Ref: 6/2022/2422/COND - Hertfordshire Constabulary Stanborough Road Welwyn Garden City AL8 6XF

Thank you for consulting us on the submission of details pursuant of condition 7 (haul road fencing and gates) condition 11 (LEMP) condition 12 (external materials phase 1) condition 18 (external materials phase 2) on planning permission 6/2021/2125/MAJ.

Condition 7 (Haul Road – Fencing, Gates and Materials) Insufficient information to discharge

Hertfordshire Constabulary Headquarters
HCHQ-VGA-HQ-XX-SP-AR-00902
Headquarters
External Materials Specification: Phase 2

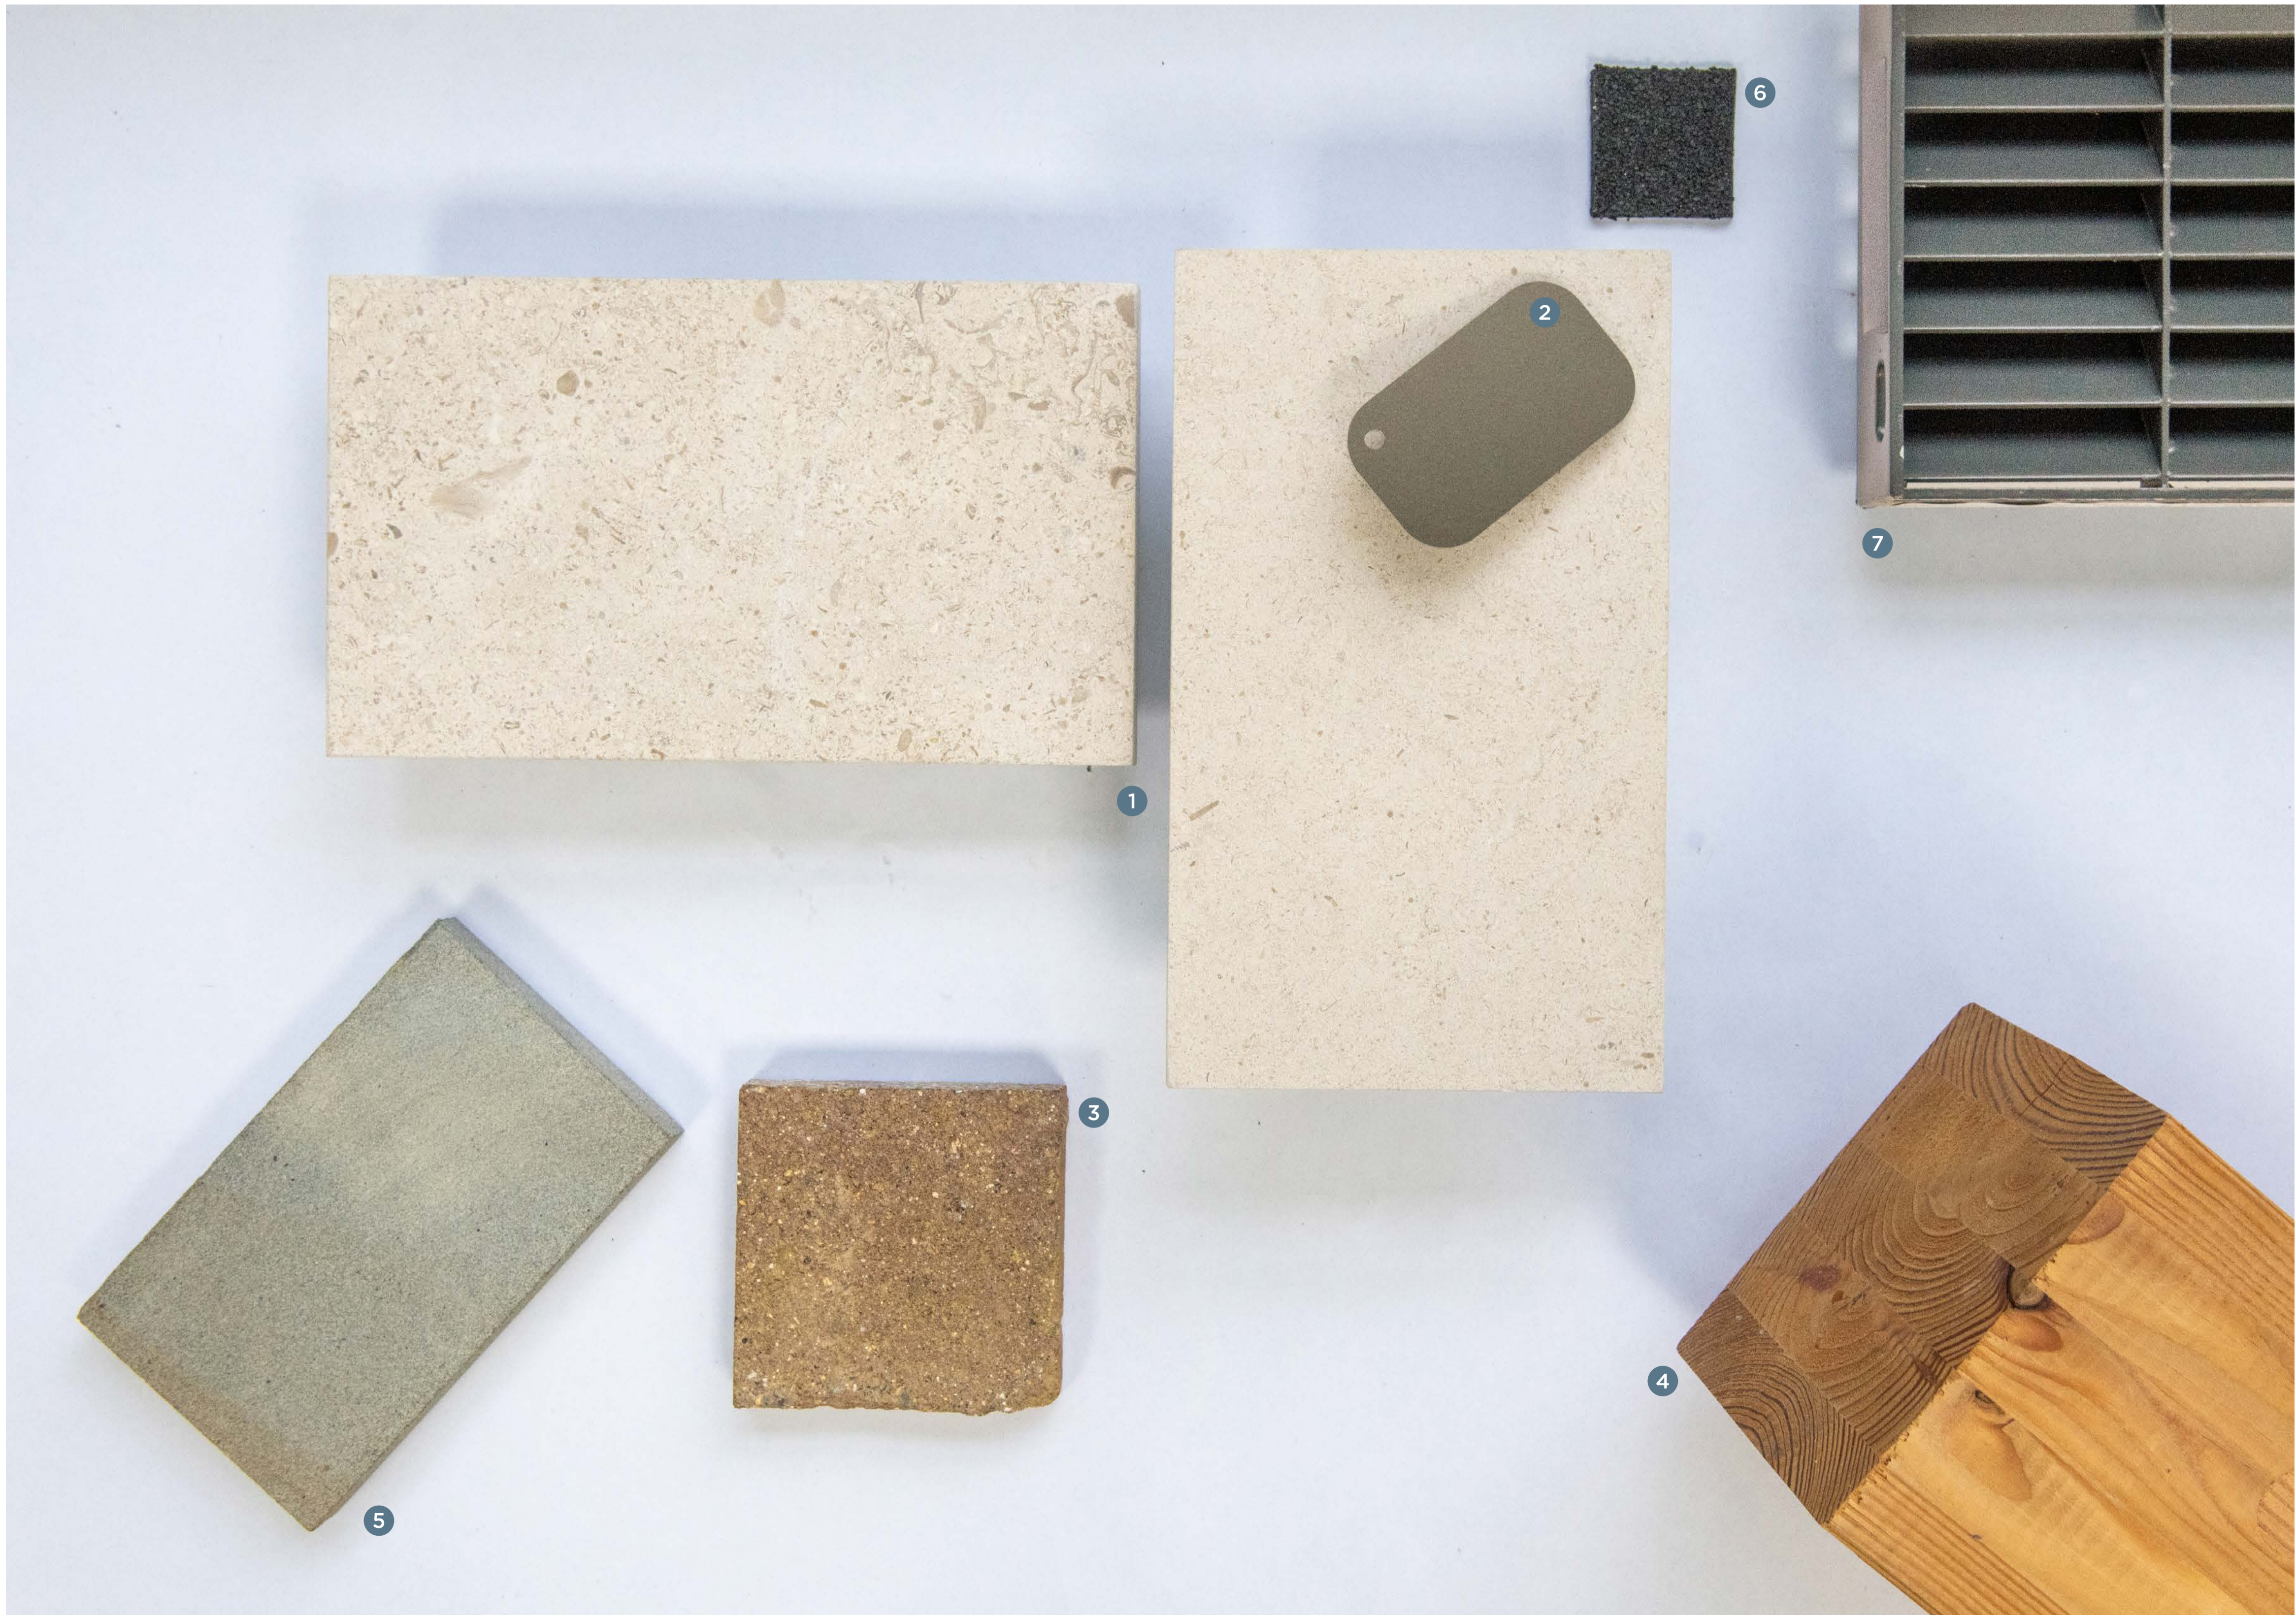
The submitted materials specification for the headquarters atrium includes Marshalls (Harvest colour) Tegula Paving to car par areas and Forest of Dean (Pennant Stone) Paving Slabs used elsewhere.
